City of Portland, Maine - Building or Use Permit Application

Permit No: 03-0360	Issue Date: MAY 29 2003	CBL: 339 D011001
-----------------------	----------------------------	---------------------

Proposed Project Description:
Build 26'x32' single family dwelling

RE: 39 Barclay Avenue – 339-D-011 &012 – R-3 Zone – Permit # 03-0360

Drawing Name: **Layout & Utilities Plan**

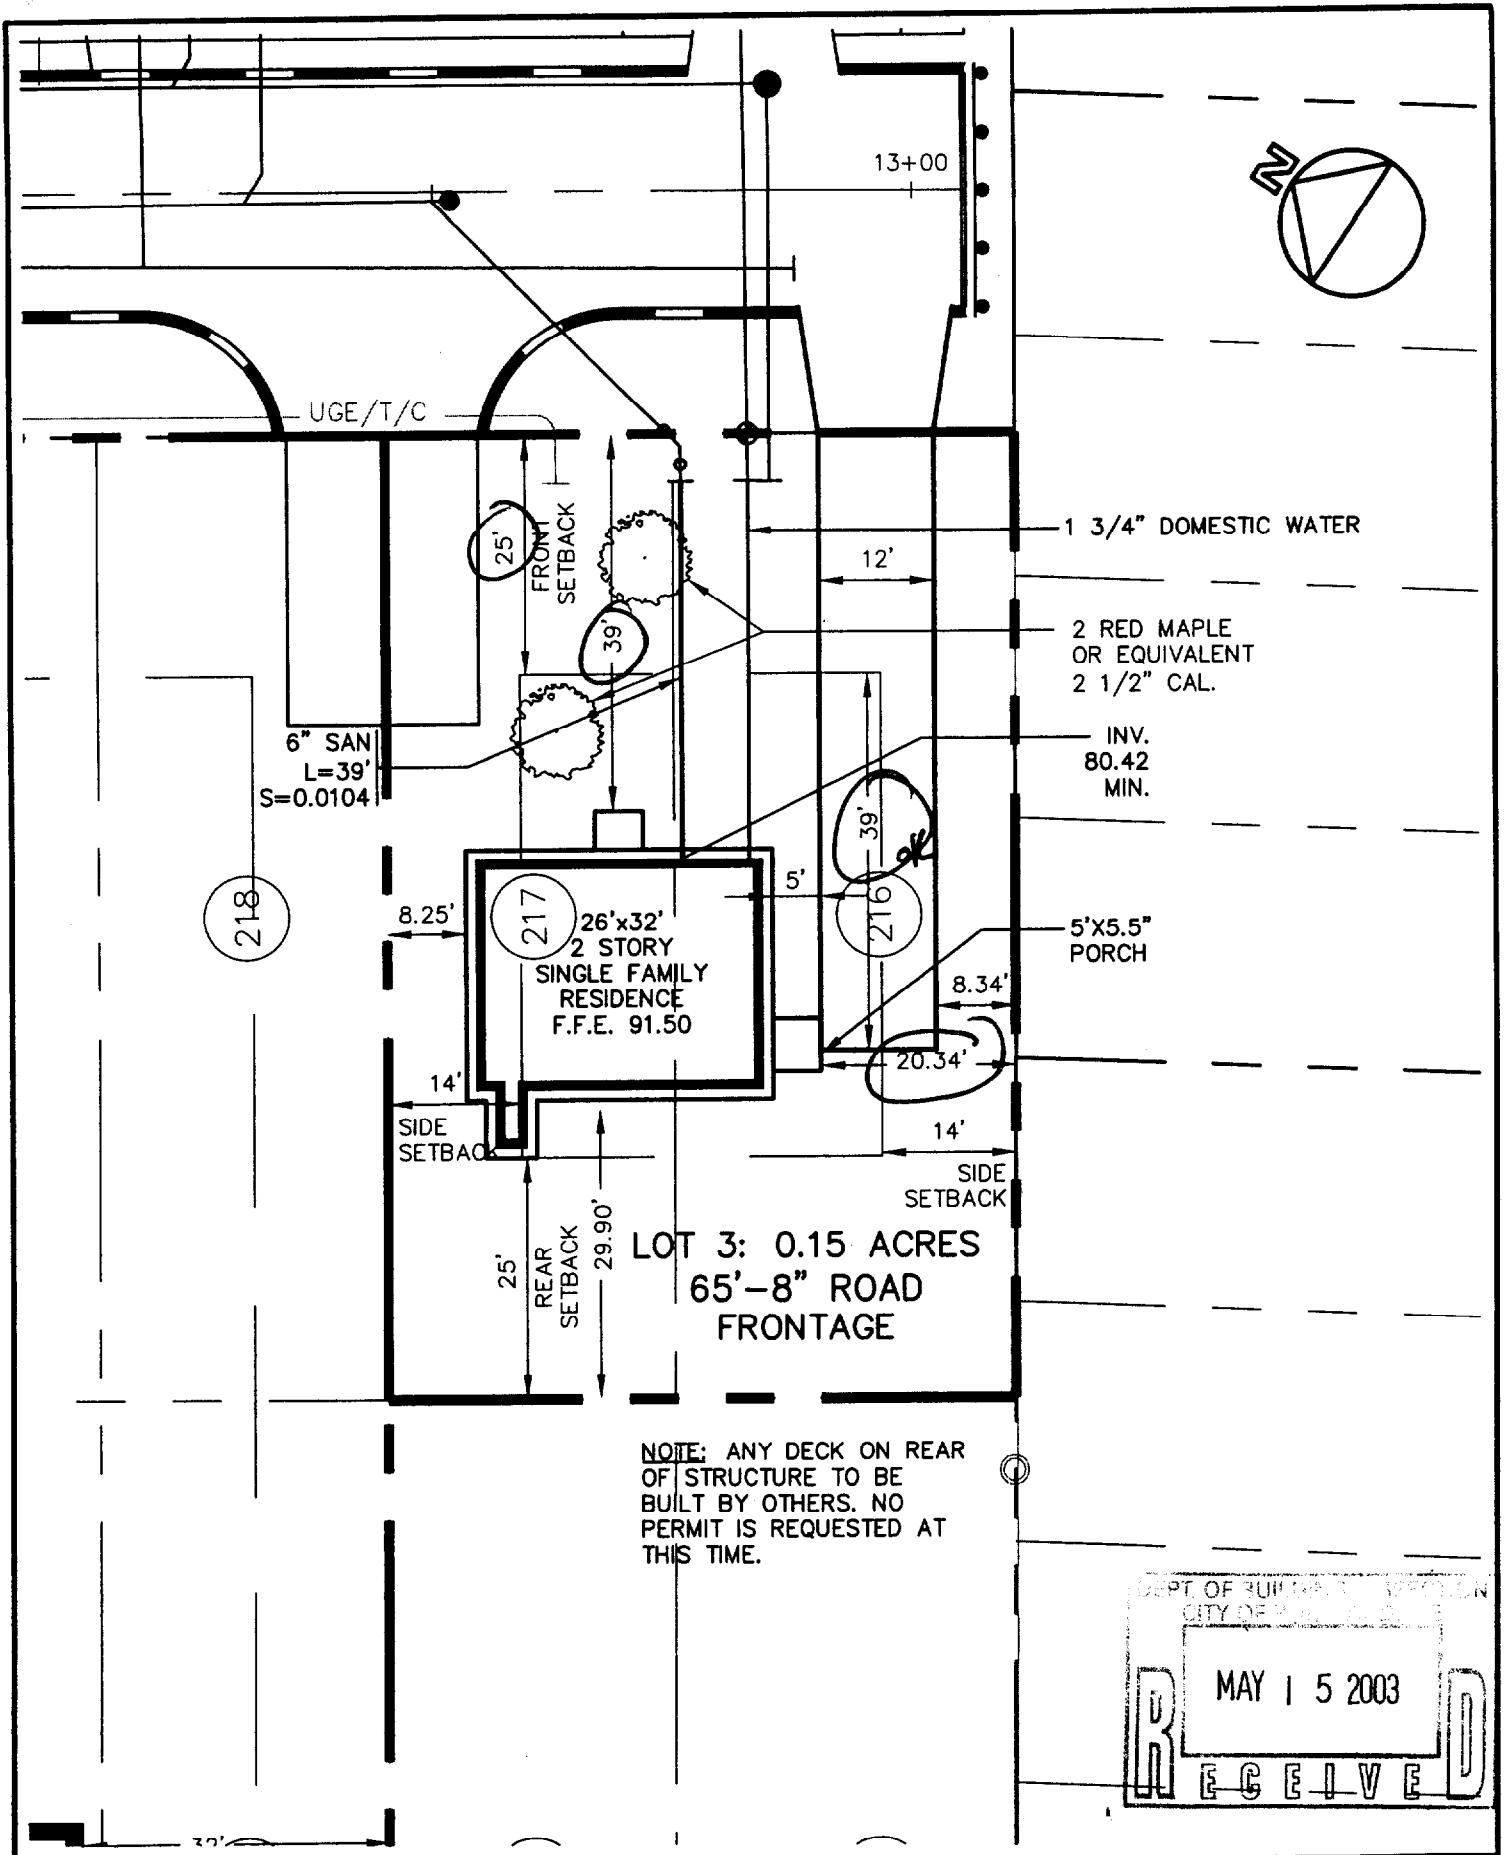
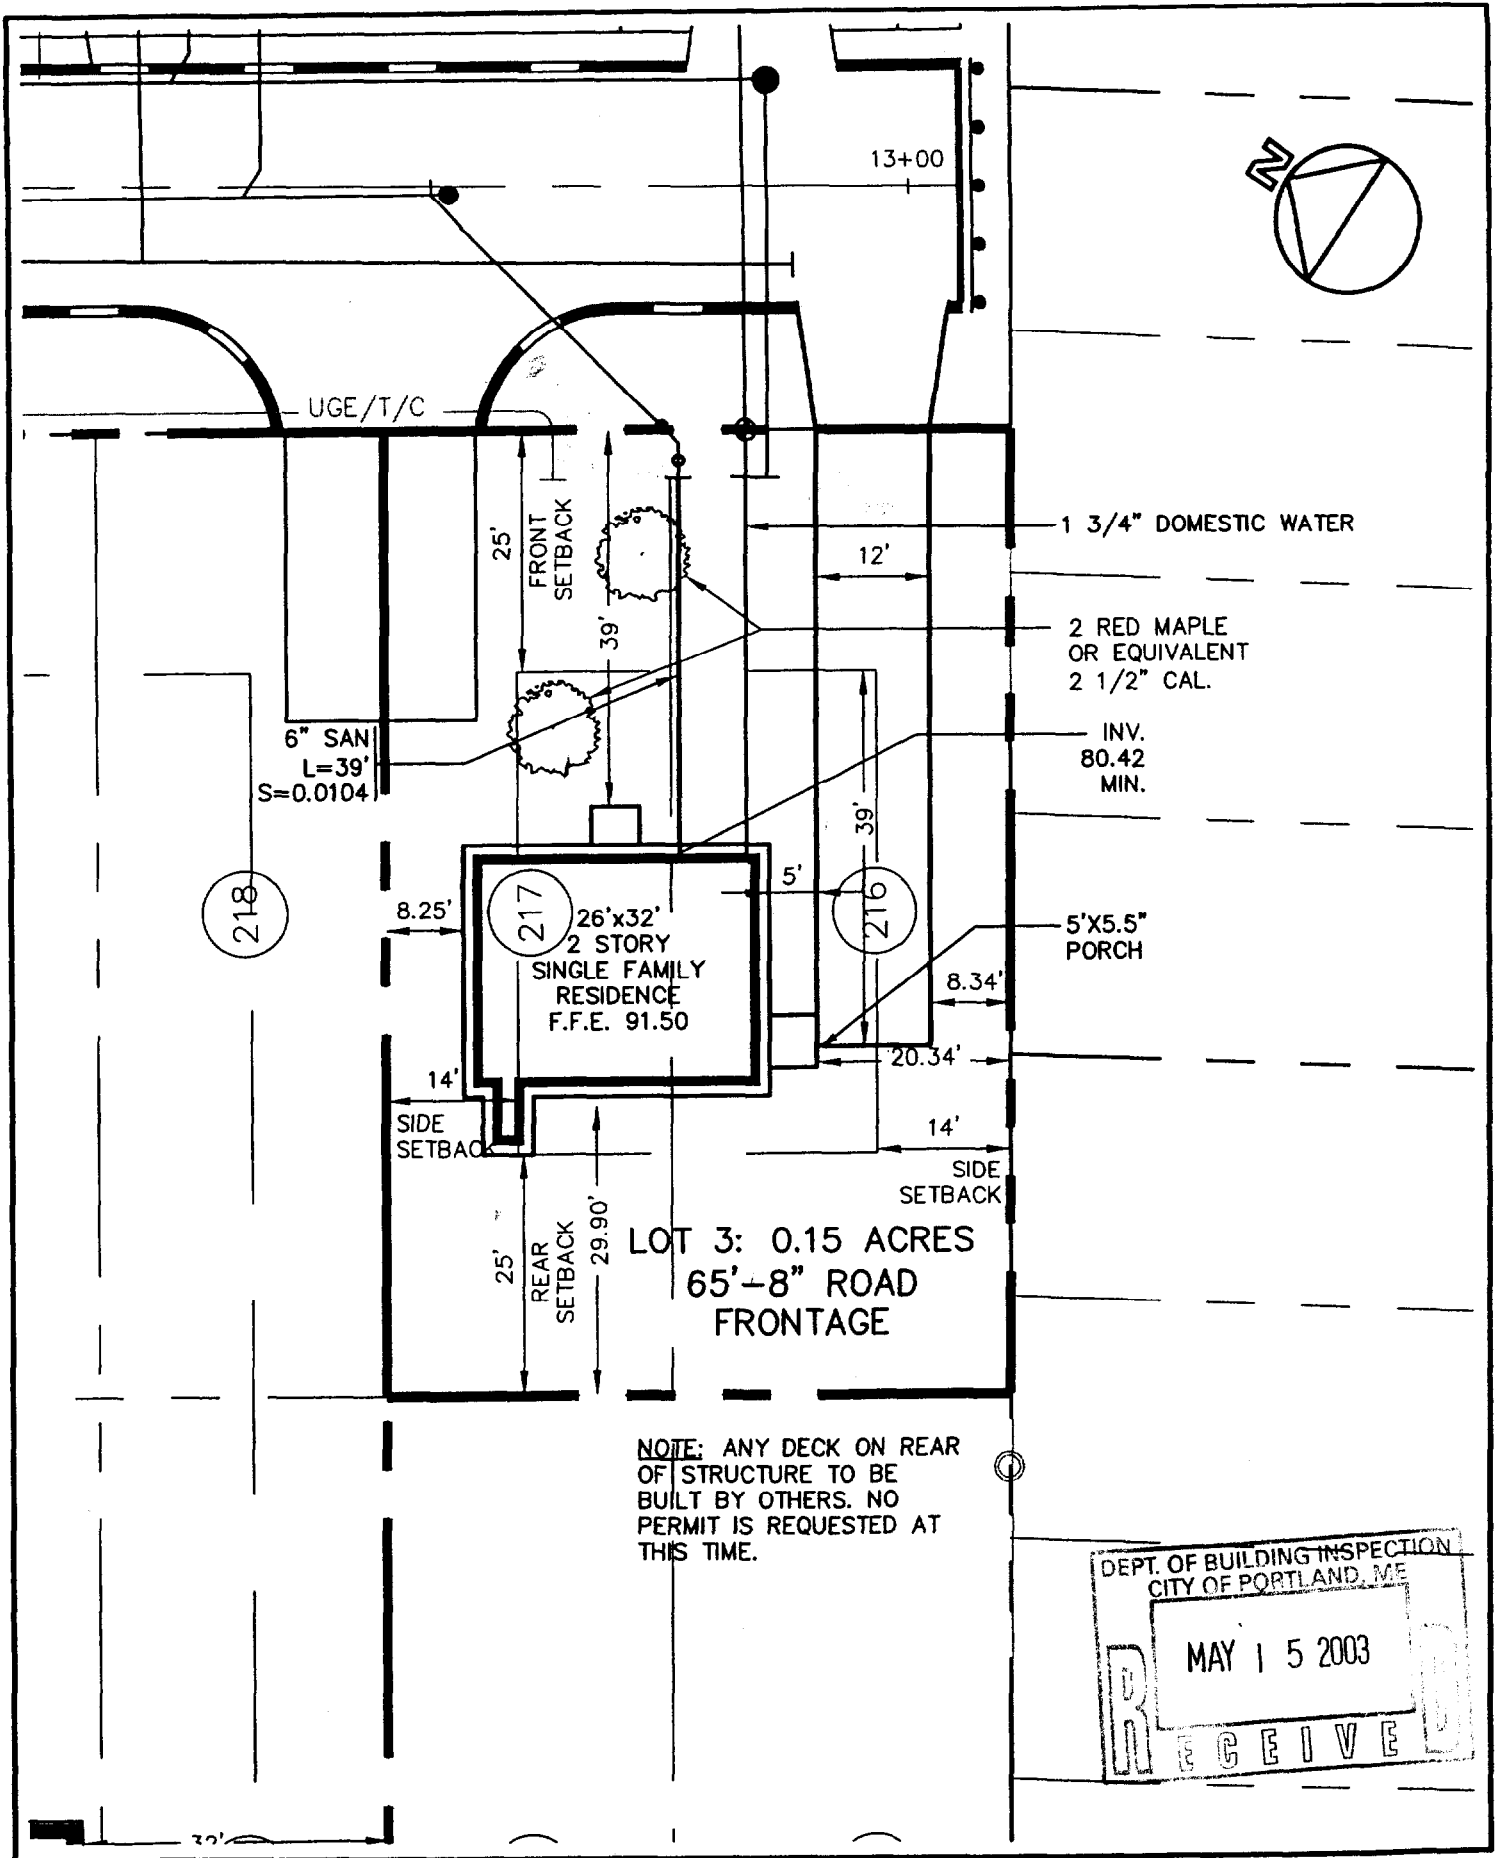
Note: 5/7/03 all zoning except the parking is ok - showing 35' from front setback instead of the 39' required for two Ok to Issue:
 (2) parking spaces will write letter
 5/15/03 revised plans show 39' feet beyond the front required front setback

I am in receipt of your permit application to construct a 26' x 32' single family dwelling. Your plans are only showing a parking area of 12' x 35' beyond the front setback line. The standards for a parking space is 9' x 19'. Therefore, two in-line spaces would require a length of 39'. If you revise your plans within 30 days of the date of this letter, I can accept that change as part of this application.

Enclosed please find the revised copies for the above referenced permit showing the changes in parking.

*parking ok per
revised plans*
